PROPOSAL: Outline application for erection of residential development	Ref. No.	GG129
	Officer	EM
	Tel No.	01484 221000/ 07890 630 720
	O.S. Ref.	
LOCATION: former Gees Garage, New Hey Road, Outlane, Huddersfield, HD3 3YJ	Date Received	14/09/2018
	Date Returned	25.10.18
	Site Area	0.67 ha

**KIRKLEES COUNCIL
TOWN AND COUNTRY PLANNING ACT 1990
STREETSCENE & HOUSING
LANDSCAPE SECTION**

PLANNING REF: 2018/92934

Site Layout

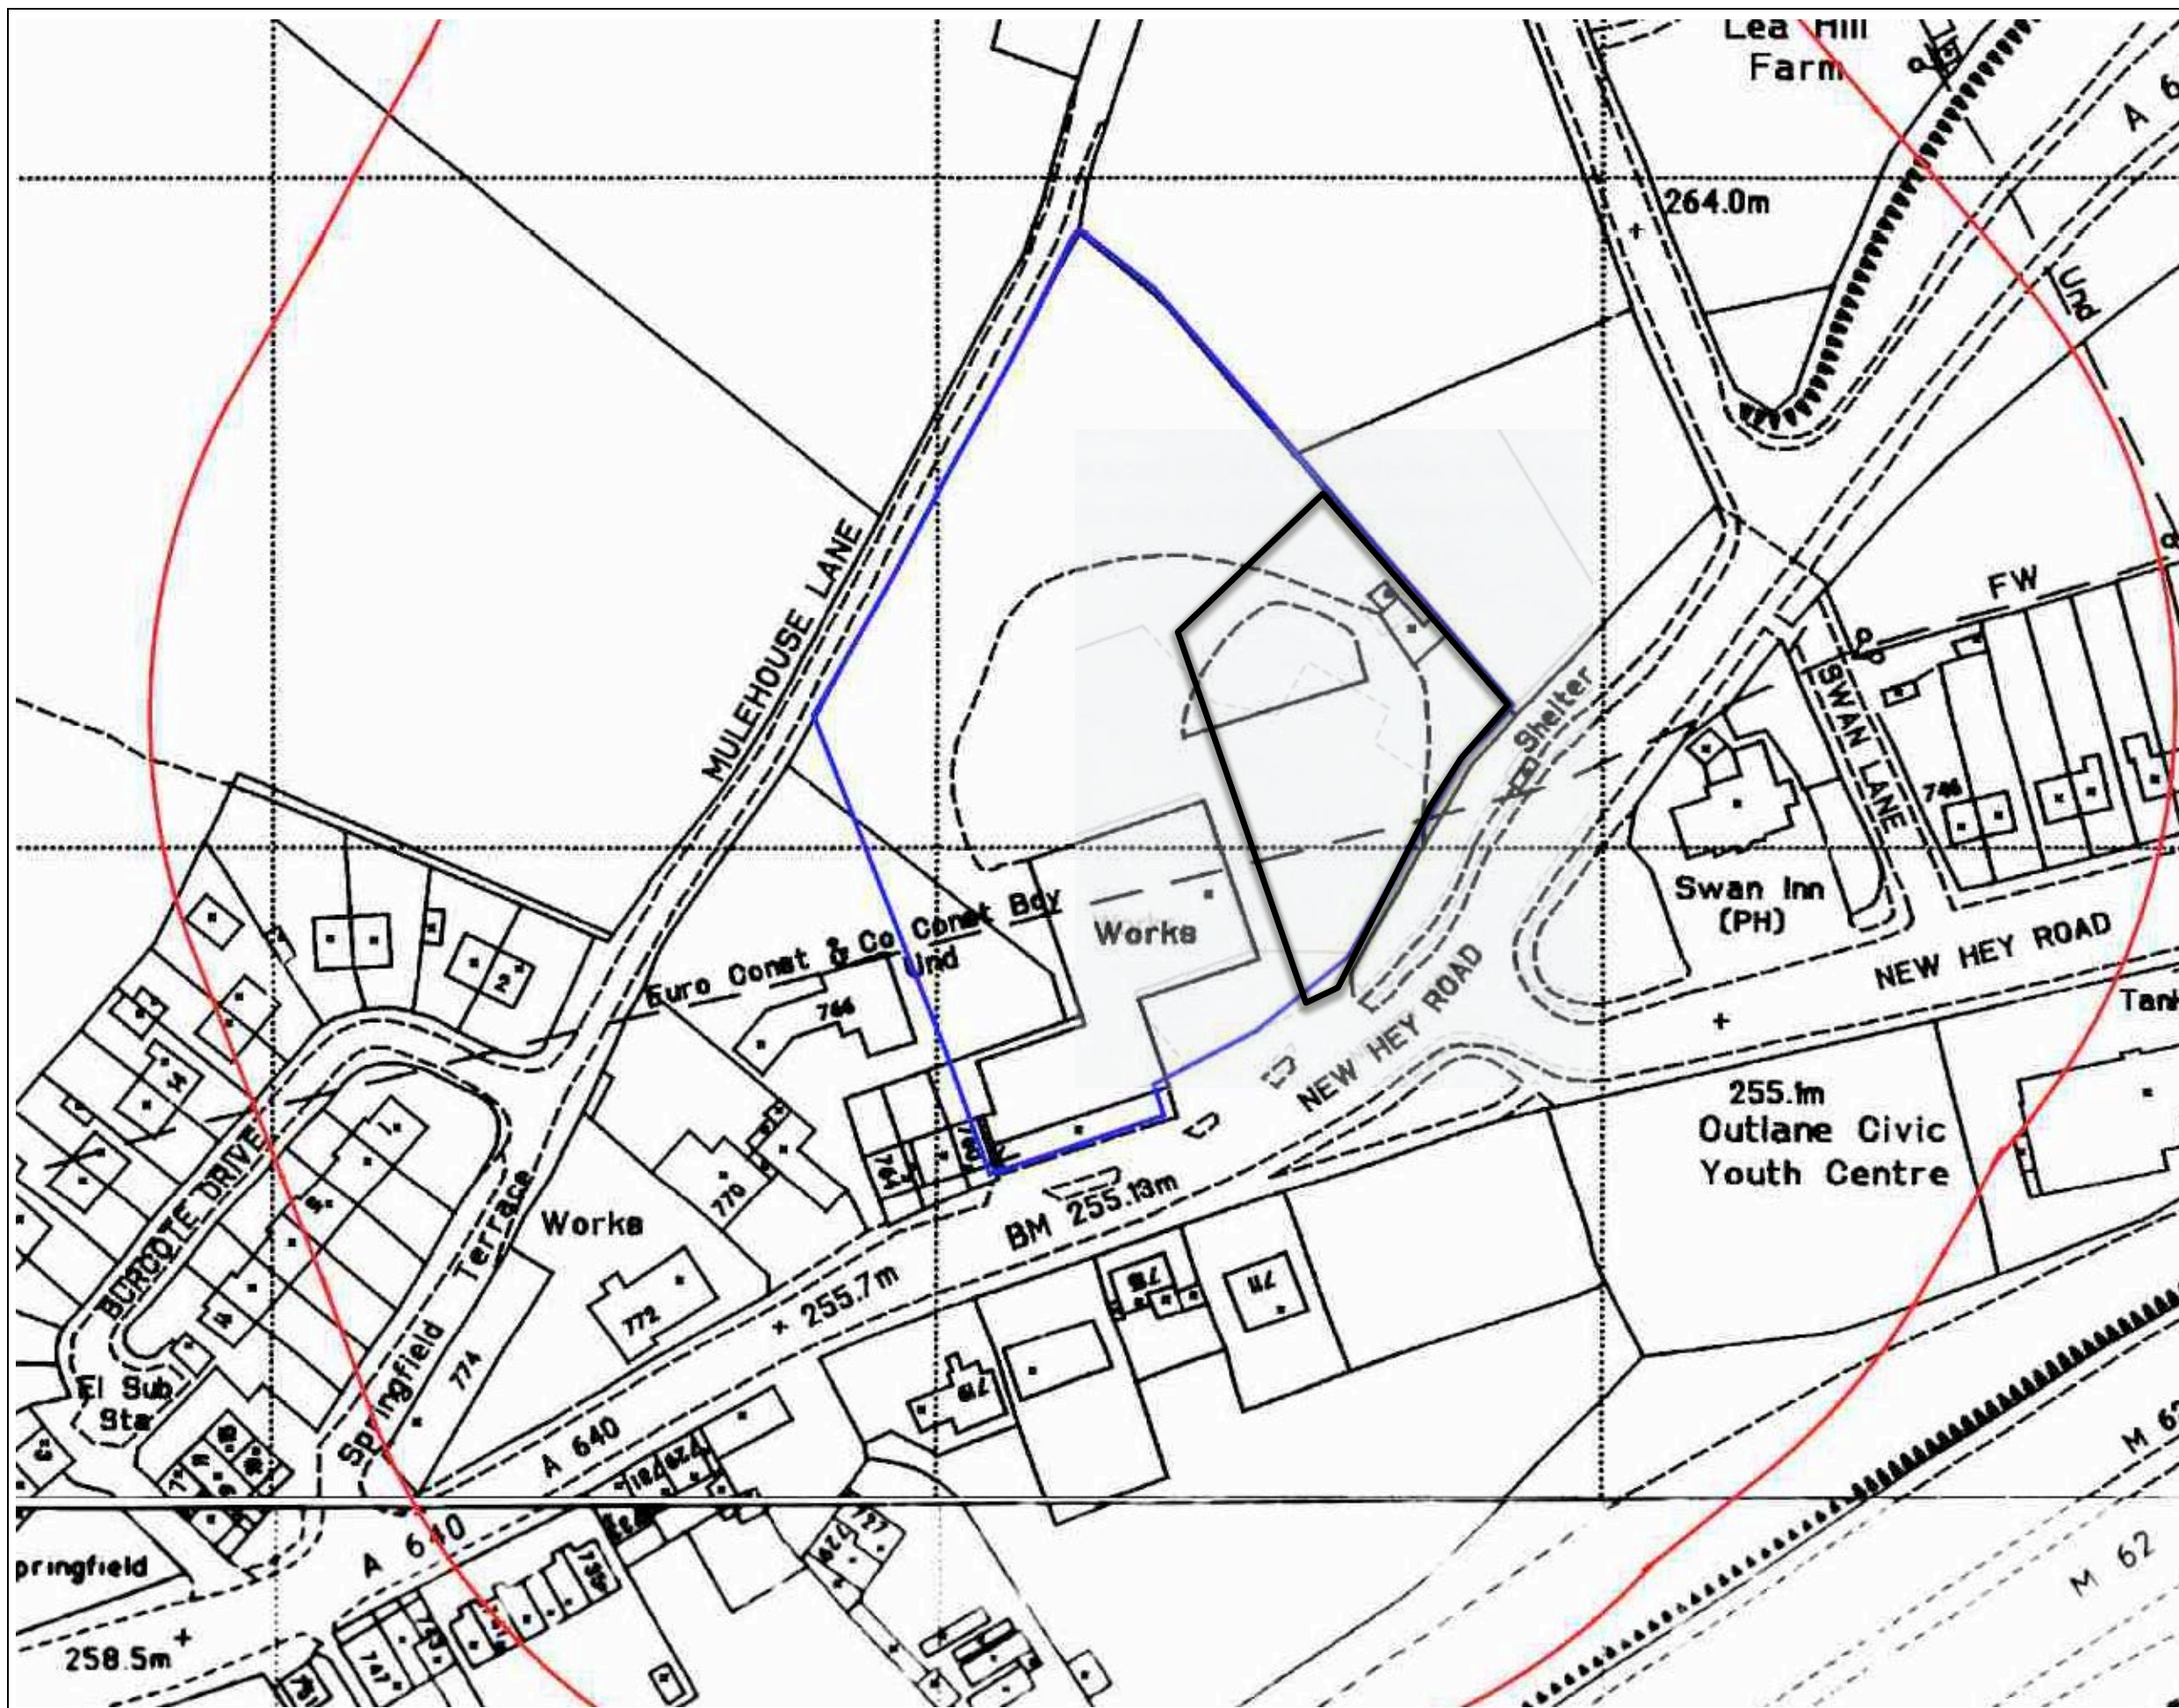
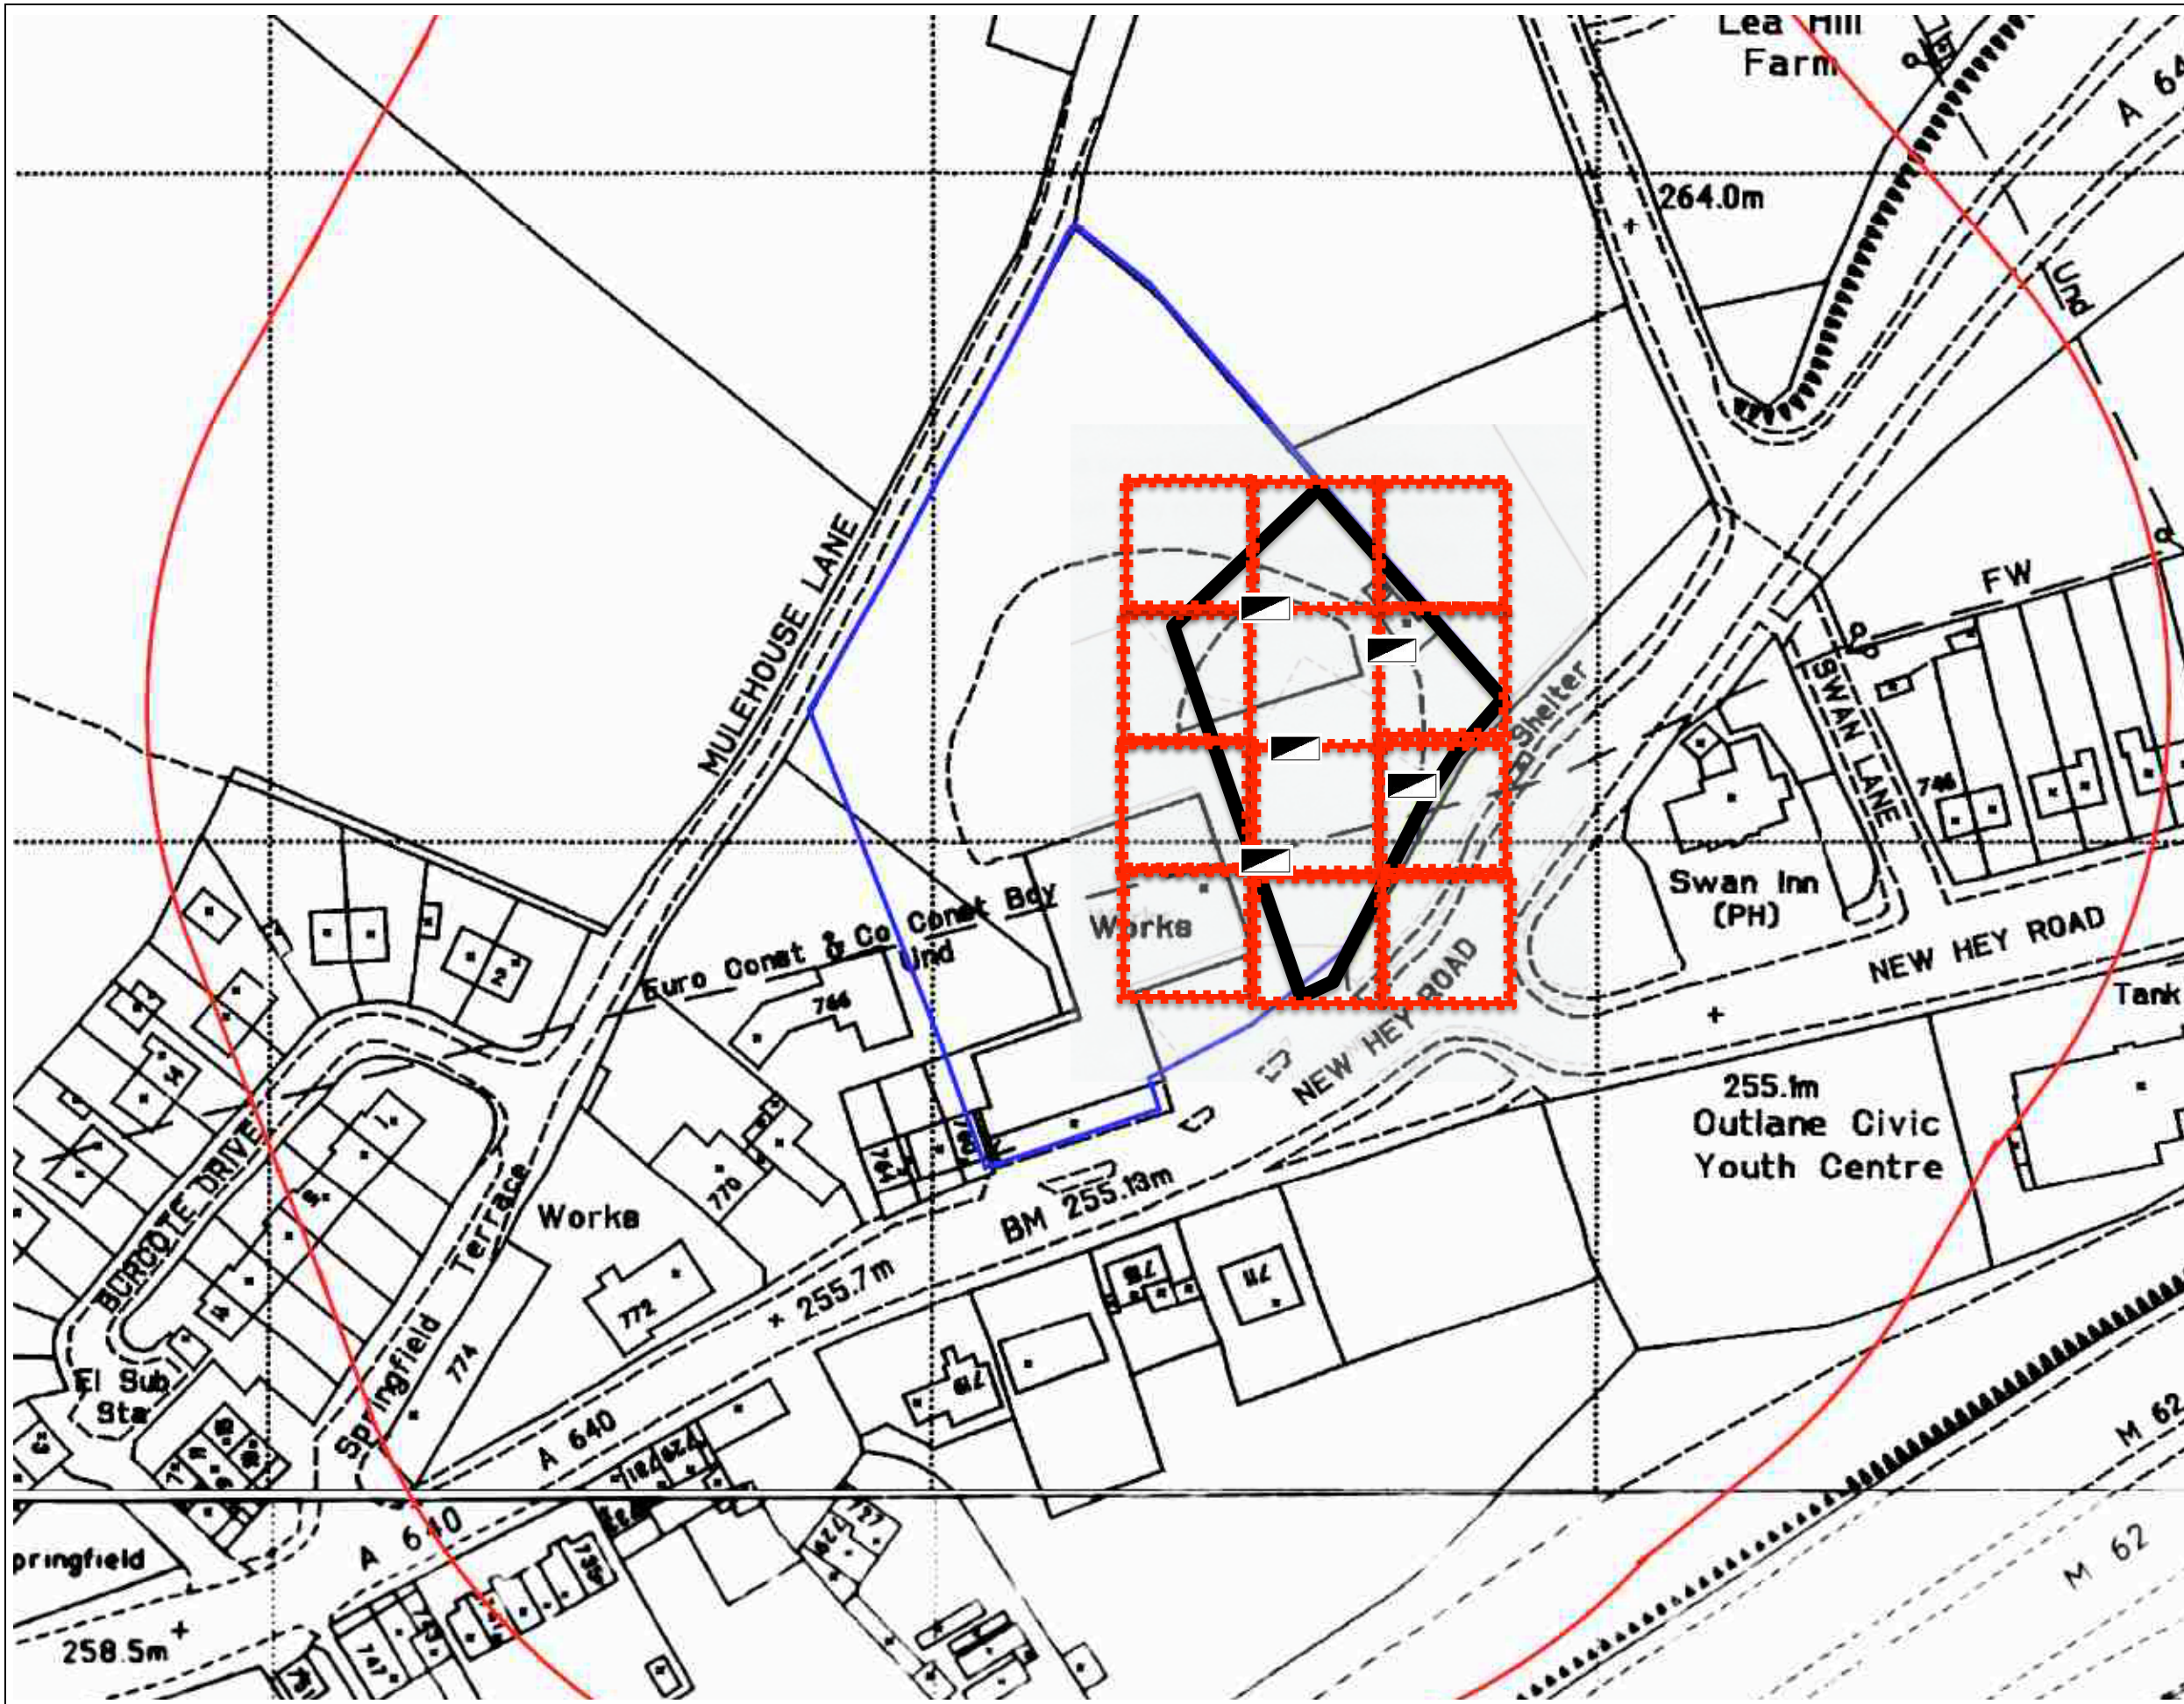
- There are extensive hard surfaced vehicular areas, 6 parking bays plus the estate road on the cul-de-sacs plus driveways, seems vehicular dominated and should include soft landscaping where possible.

- Tree planting along rear boundaries will help visually mitigate the development, this has been indicated but more detail is required. Clarification of garden boundaries is required.
- Bin storage and collection points will need to be clearly identified. Refer to point 6 below.
